Planning Application Ref: WA/99/18/DOC

Location: Land East of Tye Lane, Walberton, Arun

Description of works: Application for approval of details reserved by conditions imposed on planning reference WA/44/17/OUT relating to conditions 5, 9, **10**, 11, 12 13, 16, 17, 24, 25, 27, 28, 30, 32, 33, **36**, 41 and 43

b) Stabilizer strut mounted on block tray

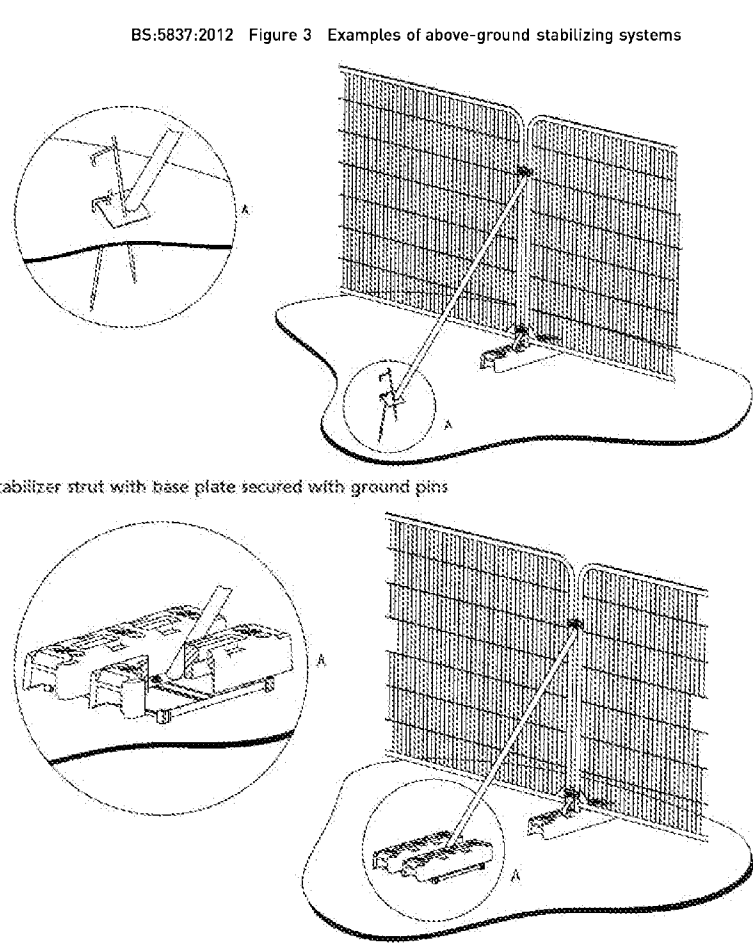
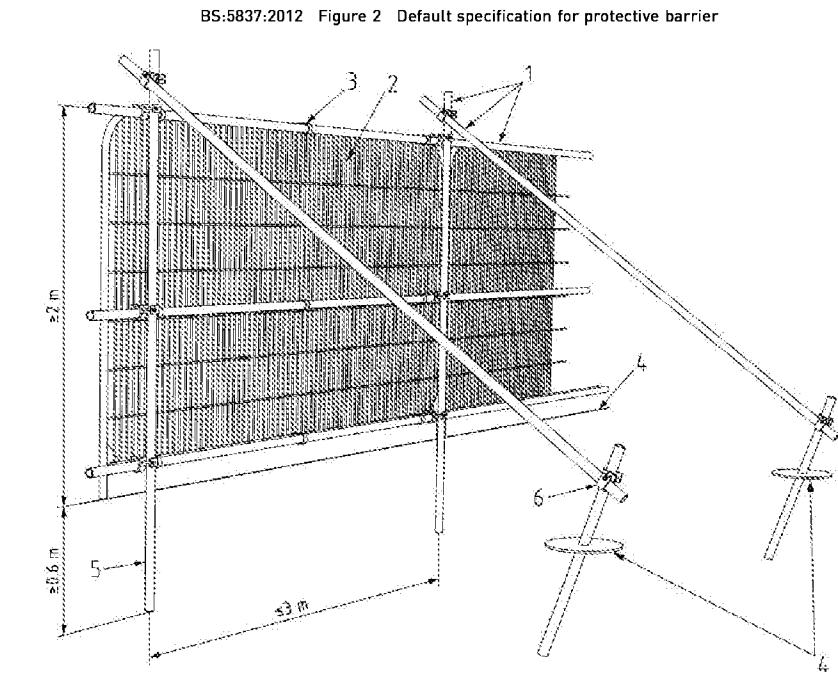
- Perimeter fencing is for the most part double-clamped and all is sat in block trays. This will not be acceptable for the 'construction phase' of the development and does not entirely meet the requirements of the approved plan/AMS.

- There are no informative notices affixed to panels at regular intervals (Construction Exclusion Zone – Keep Out!).
 - Stabilising struts will need to be installed on perimeter fencing at regular intervals.

- I recommend we await photographic evidence and written confirmation from the project arboriculturist, which demonstrates that the above list of items have been satisfactorily addressed – before discharging conditions 10 and 36.
